CITY OF ALBUQUERQUE

RE: Valle Prado Units 1&2 - Tracts 9 and OS-3 (File: C09D011)
Drainage Report for Valle Prado at the Trails Units 3A,
Engineer's Stamp Date 6-24-2014
Revised Grading and Drainage Plans, Engineer's Stamp Date 7-10-2014
Supplemental Calculations, Engineer's Stamp Date 7-10-2014
Revised Inlet and Storm Drain Network Map, Received Stamp Date 7-10-2014
Revised Preliminary Plat, Received Stamp Date 7-10-2014

Based upon the information provided in your submittals received 6-24-14 and 7-10-14, the above referenced submittals are approved for Grading Permit with the following exceptions:

GRADING PLAN

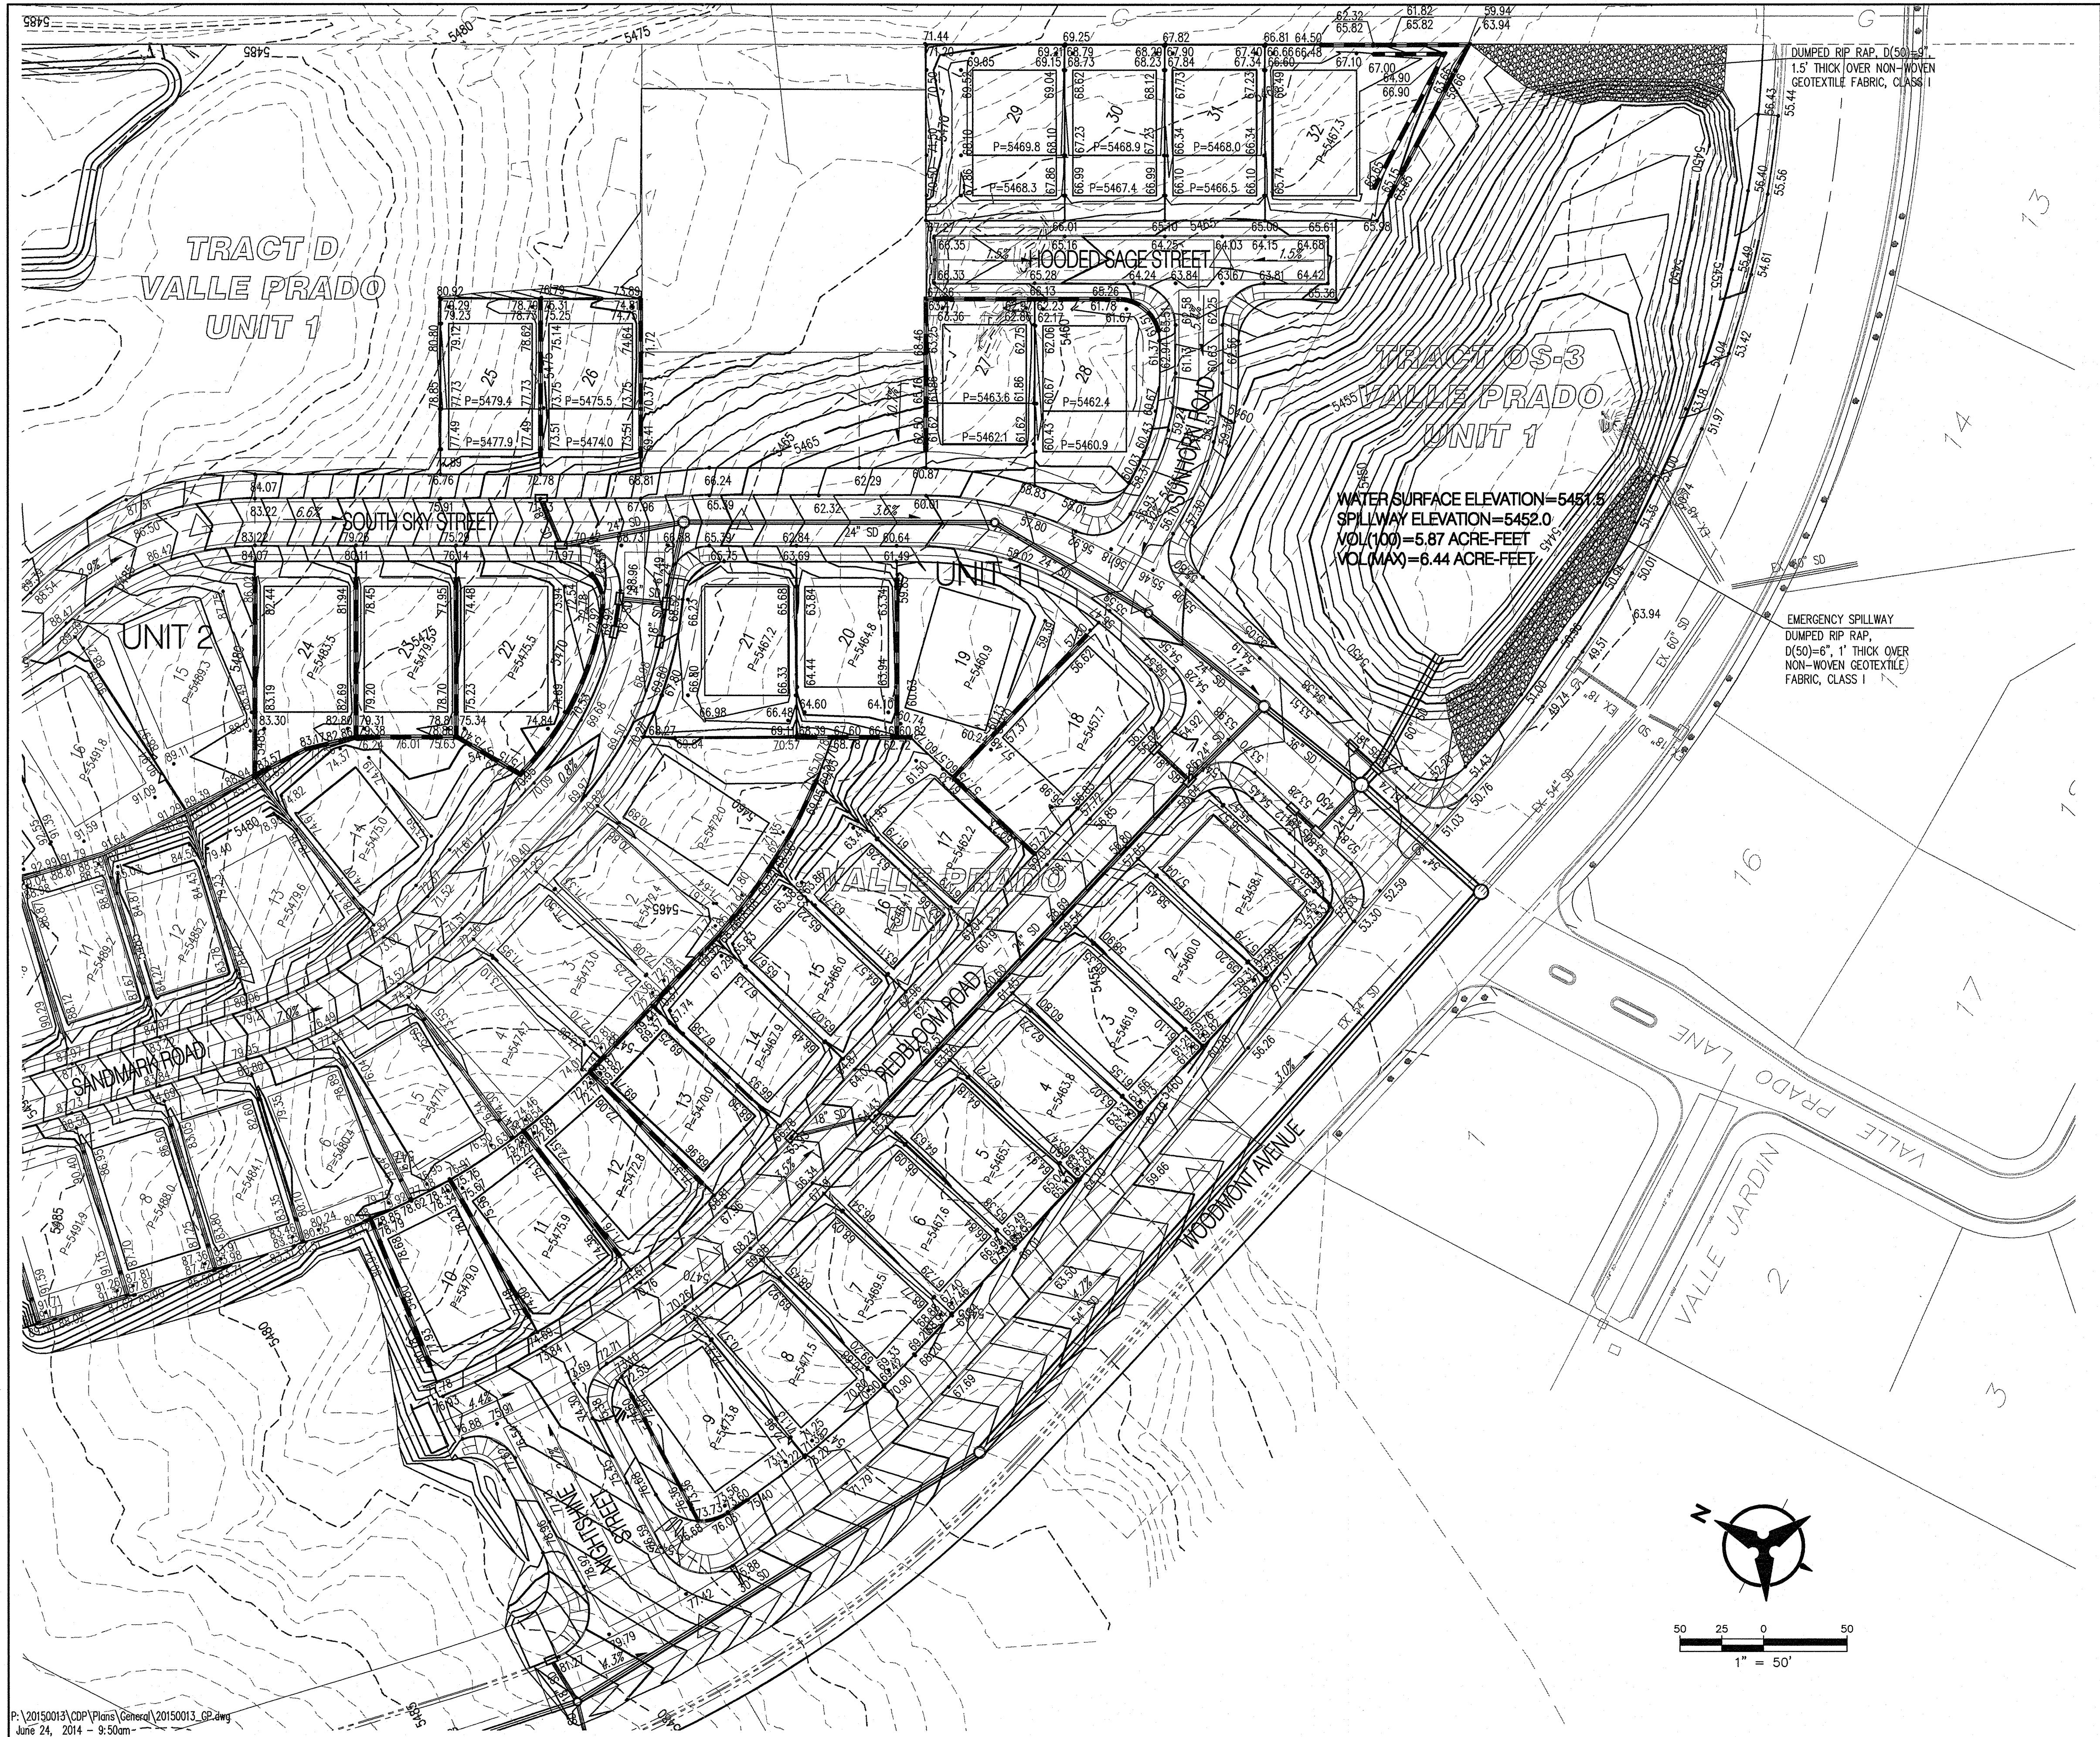
- 1) A cap should be shown on the Woodmont SD, east of South Sky Street on the Grading and Drainage plans, or at least on the As-builts.
- 2) The temporary pond should note that the Volume shown is for the developed flows only, and the undeveloped discharge calculations are part of another project.
- 3) On Sheet 1 of Grading and Drainage Plan, is that a wall between Lots 17 and 18?

VALLE PRADO FULLY DEVELOPED BASIN MAP

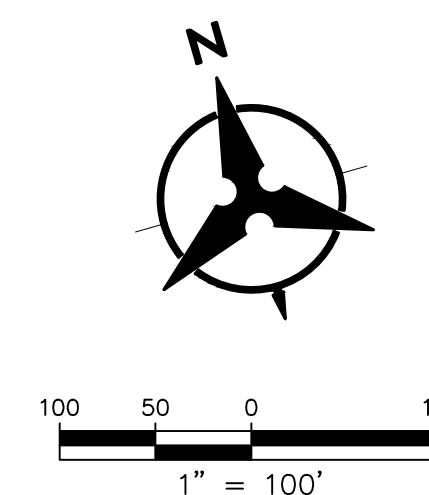
- 4) A typo on the Inlet and SD Map shows Inlet #6 as "IN4"
- 5) Verify that the capacity for SDP6 is 269.5 cfs. It seems relatively high.
- 6) On the Fully Developed Basin Map, the basin boundary is missing between Basin 1 and 3
- 7) In the Drainage Report, page 2 has a typo in last paragraph and should be "...Basin 5 (3.1cfs), ..."
- 8) Resubmit the INROADS Storm Drain Network File(Appendix C), to be reflective of the of the current SD Map.
